**Consultation Response from KC,
Trees**

2023/93503 Land off, Roslyn Avenue, Netherton, Huddersfield, HD4 7EW

**Outline application for residential development of 82 dwellings and associated works, with
layout and access as considerations**

Date Responded: 25.01.2024

Proposed Site Layout - NTS

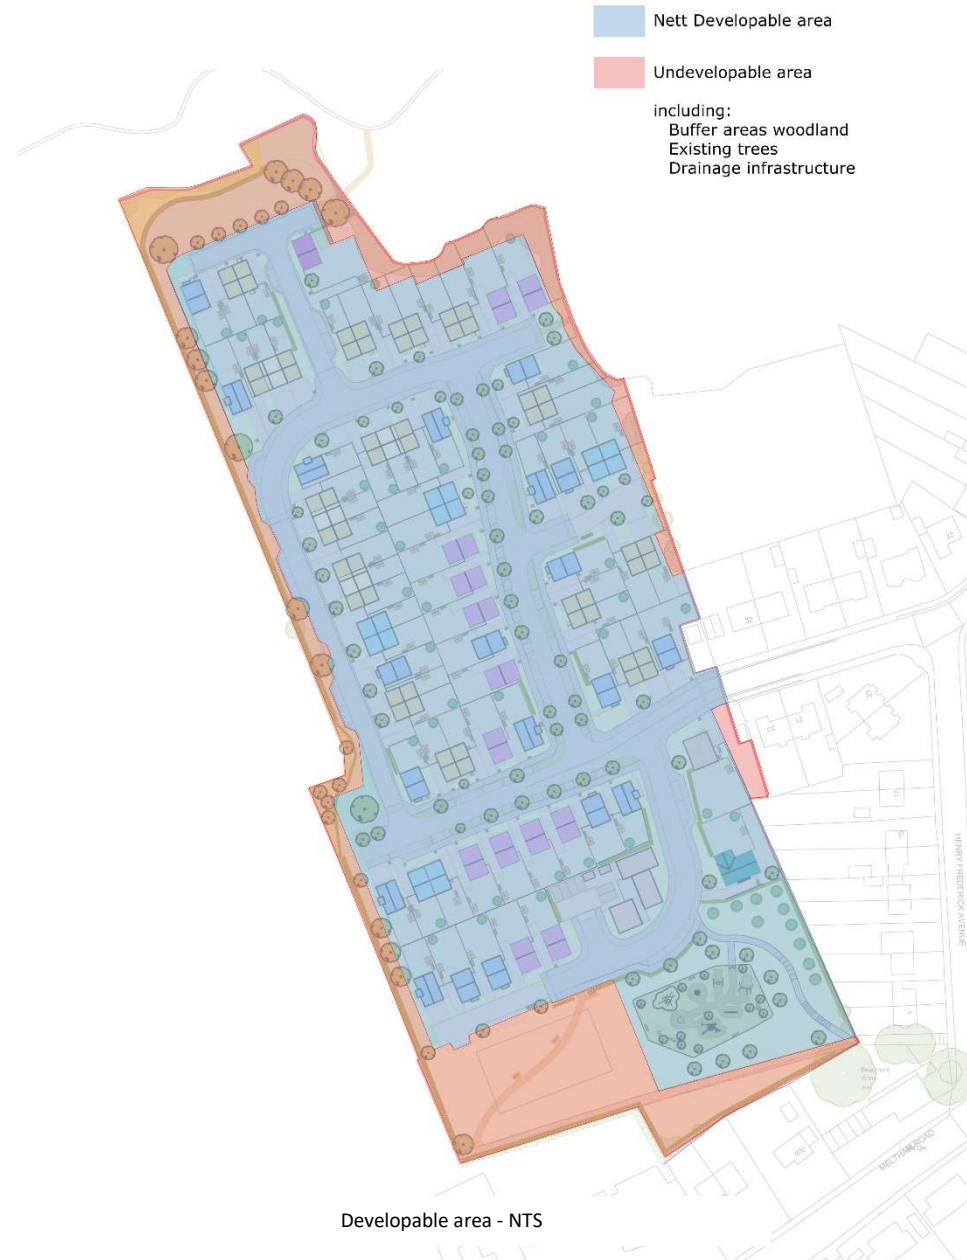
To the north of the site there is an area of ancient woodland which is also protected by TPO HU1/49/w10. The current proposals show that the development would not impact on these protected trees but may have minor impact on some boarder trees which are not protected under the TPO.

The protected trees to the north of the site have been left a 15 meter buffer zone of a grassed area which should offer protection to the ancient woodland.

This means providing no machinery or materials are stored in this area during the construction phase there should be no impact on said trees. This would need to be detailed in an Arboricultural method statement.

With regards to the unprotected trees to the east of the site. Selective pruning has been proposed in the AIA to several trees. The work proposed is only to gain clearance from two potential properties and would not affect the overall aesthetics of the trees or impact on their health if it is carried out to BS3998 standards. The works are very minor and wouldn't change the overall landscape as it currently appears.

There are no objections from a trees perspective subject to the following conditions: An Arboricultural Method Statement is provided at full application stage detailing the proposed pruning work and also the tree protection measures to all trees adjacent to the site. An Arboricultural site monitoring schedule would be advised in relation to the protected trees to the north of the site to guarantee tree protection measures are being upheld.
